OUT16/48733

**Oakdale South Industrial Estate (SSD 6917 MOD 1)
Comment on the Environmental Impact Statement**

Mitchell Isaacs
Director, Planning Policy & Assessment Advice
14 December 2016

Figure 3-1. Watercourse Realignment Management

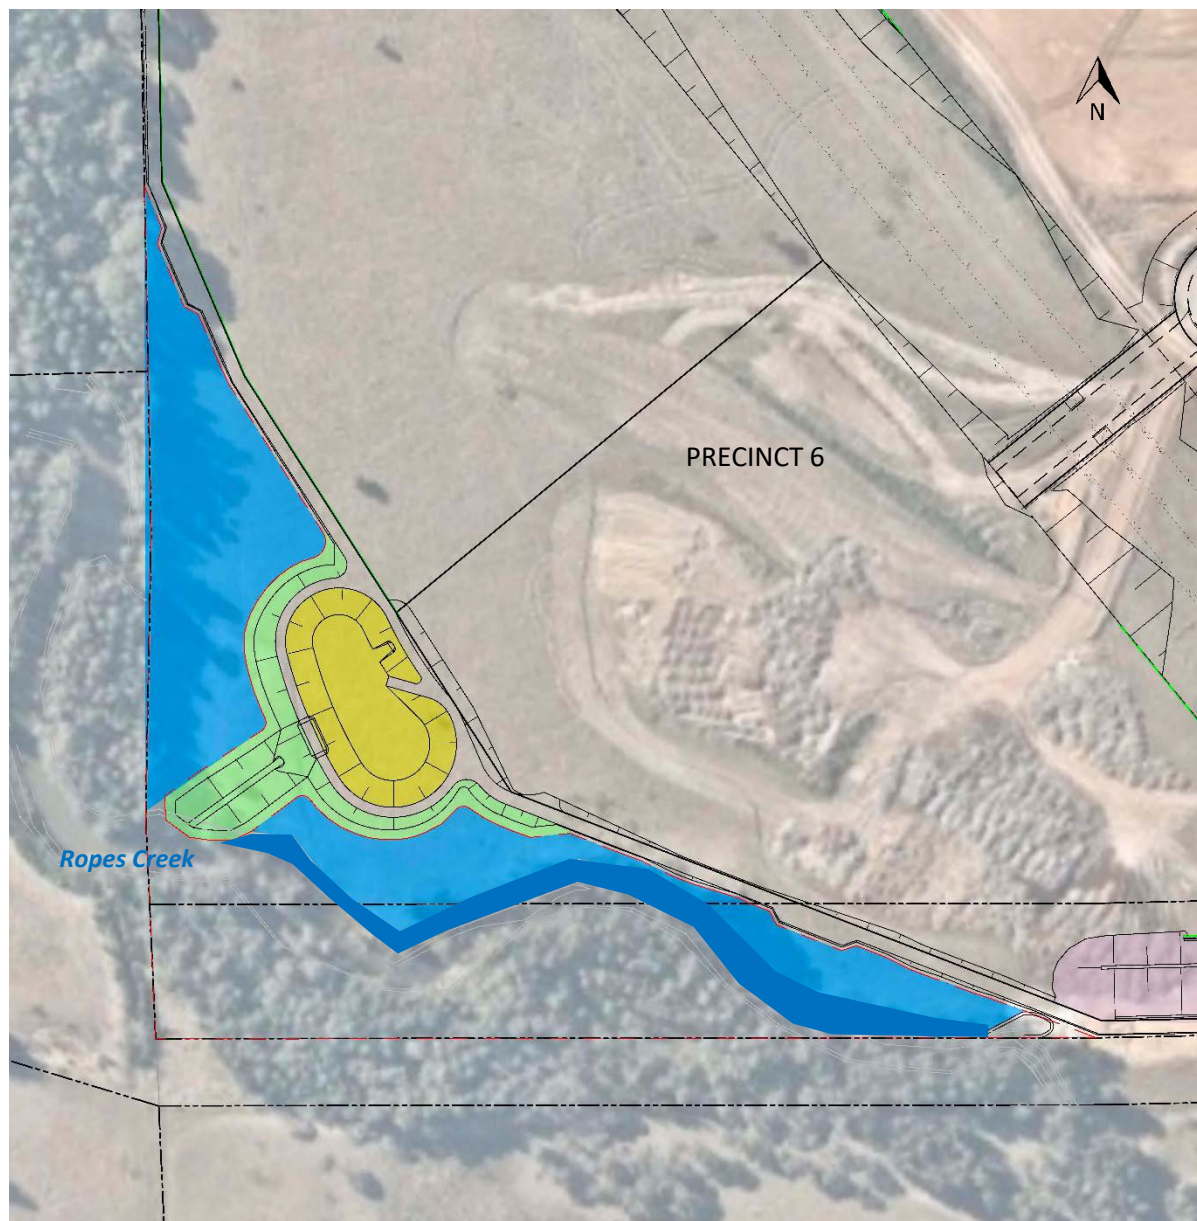
- The following should be included as conditions of consent to any approval of the project:
 - The proposed modifications associated with the realigned Ropes Creek Tributary should be consistent with DPI Water's [Guidelines for Controlled Activity on Waterfront Lands \(2012\)](#).

- The design of the culvert crossing under Estate Road 1 should facilitate fauna passage.
 - The waterway realignment area should be restored to a stable, naturalised system that mimics natural creeks from the local area.
